Jean Fraser - Re: 133 York- need comments today please

From: Chris Pirone
To: Jean Fraser
Date: 9/6/2013 8:42 AM
Subject: Re: 133 York- need comments today please

SITE PLAN MAP 44/BLOCK A/LOTS 29 & 31

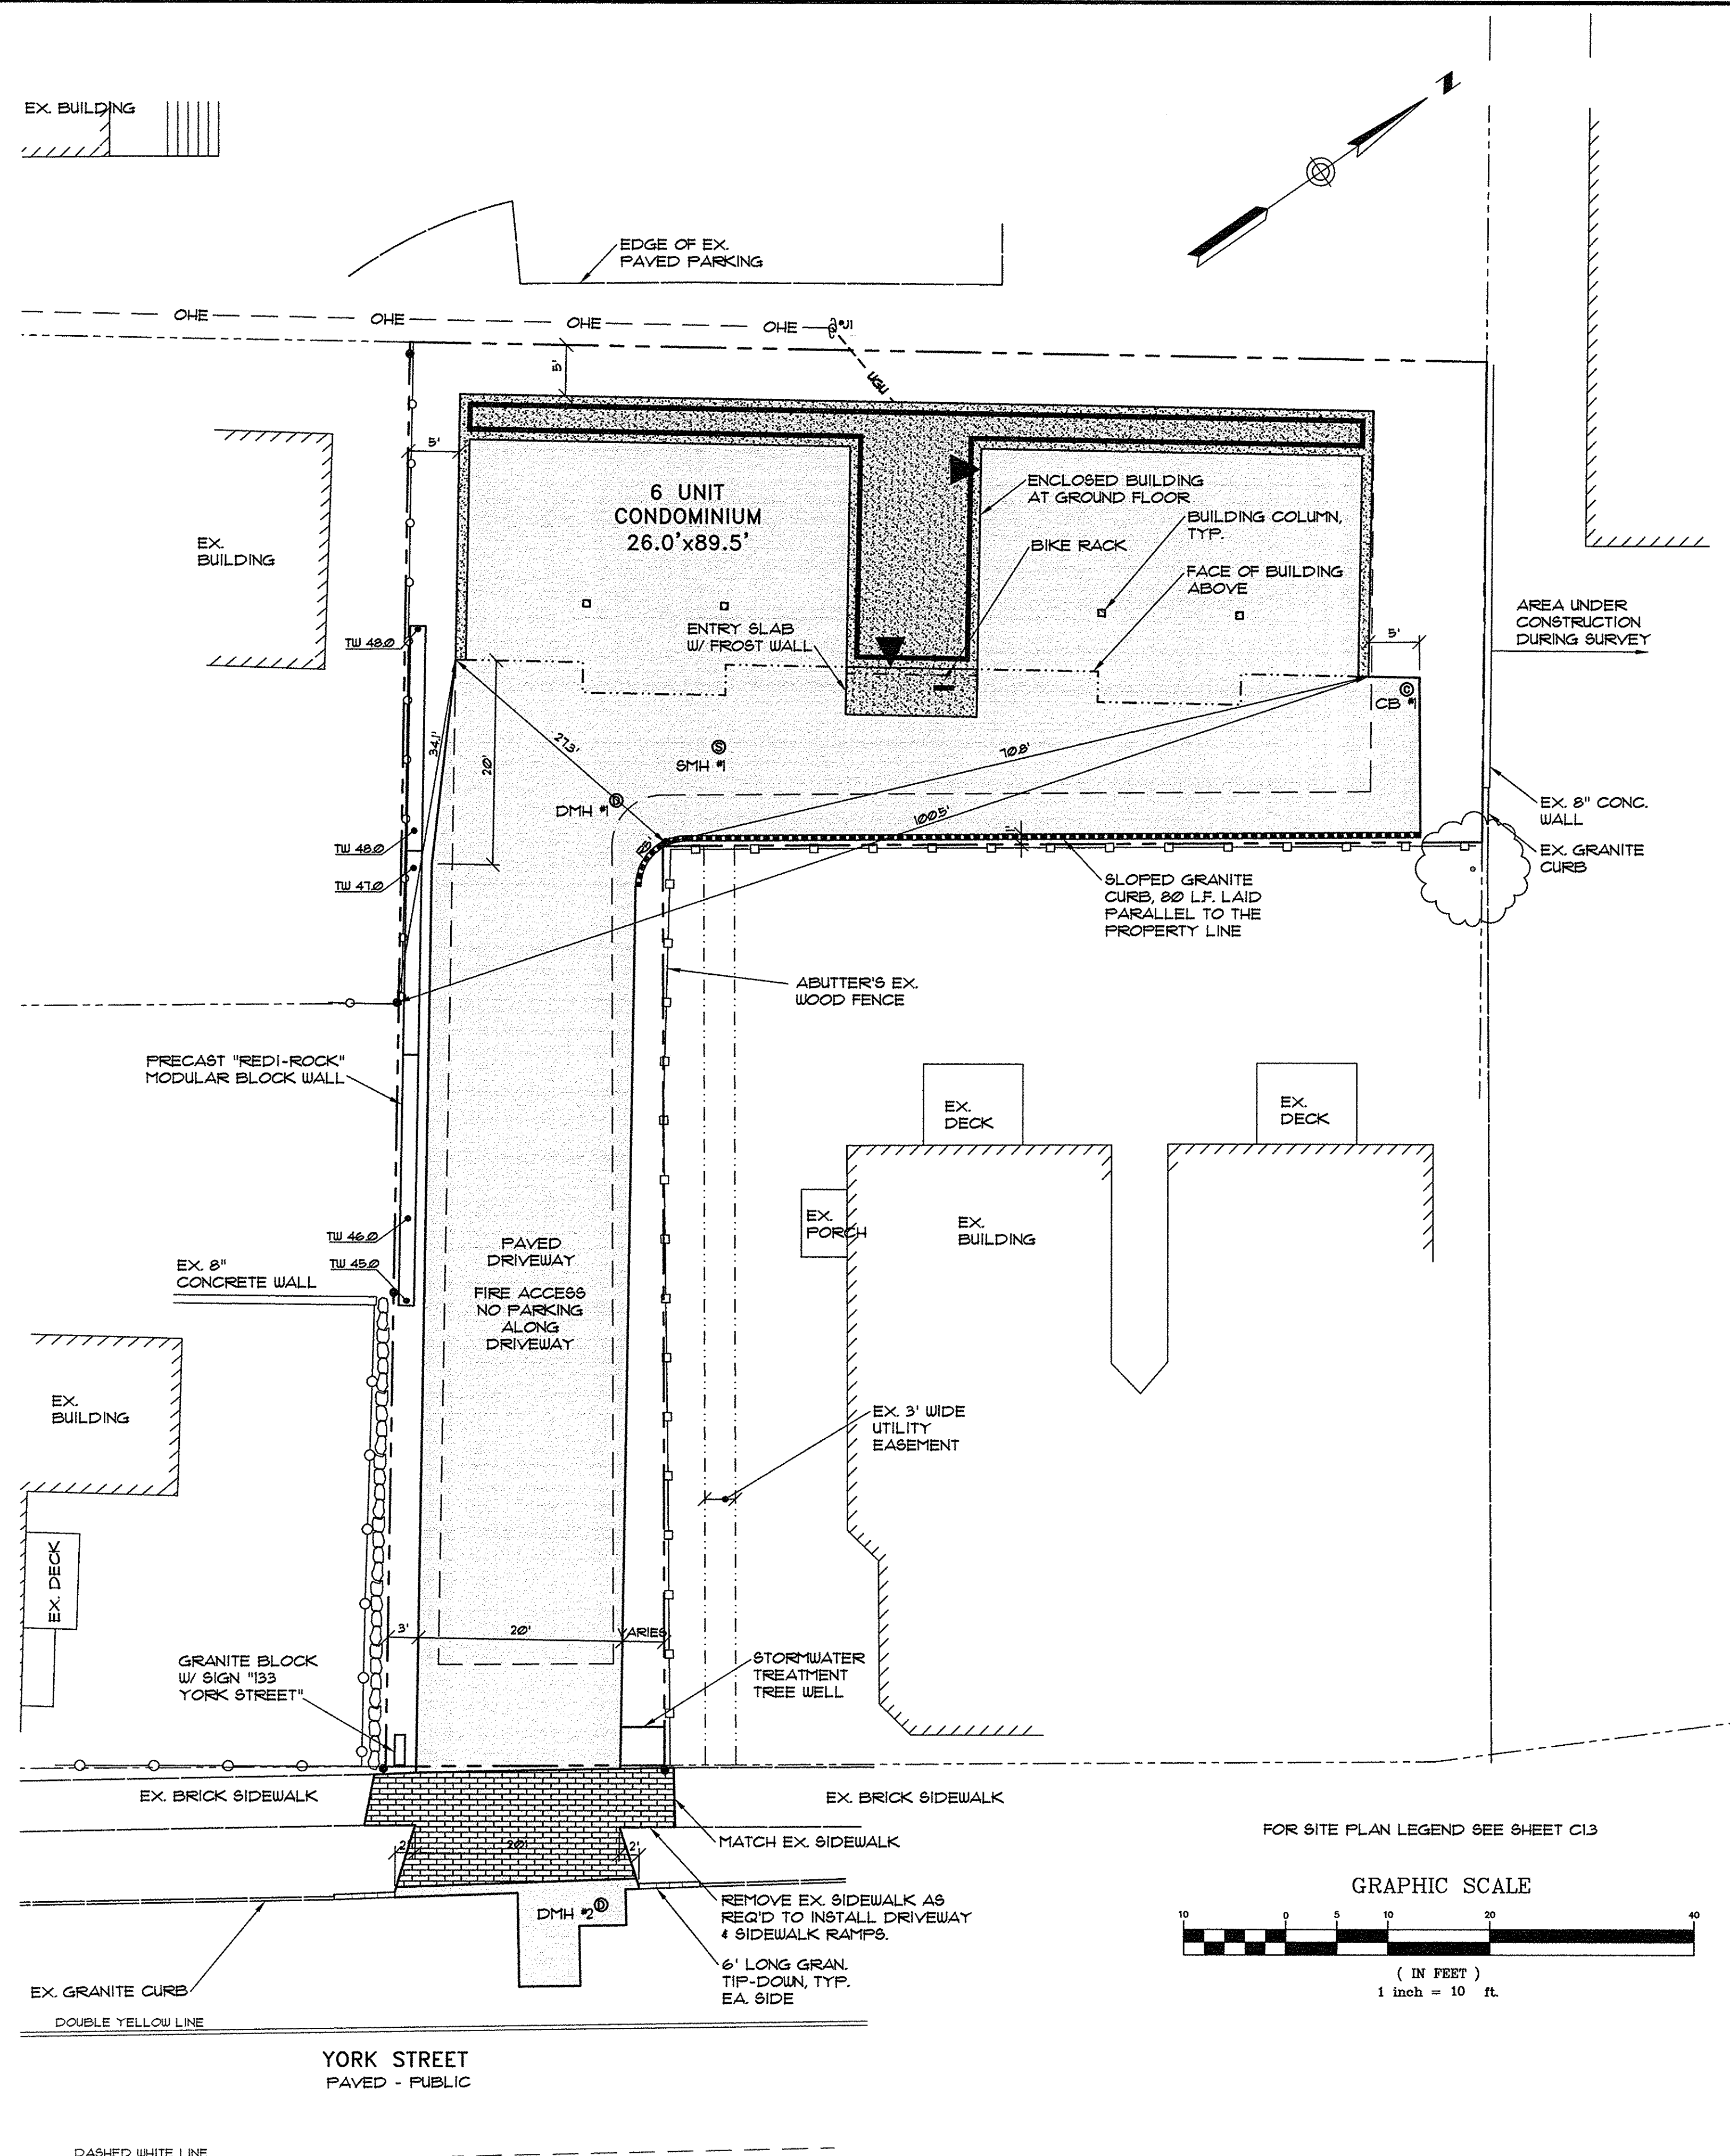
1. 20' access for fire fighting operations to and in front of the sprinkled structure.
2. FDC on York St. due to structure being set more than 100' from nearest hydrant.
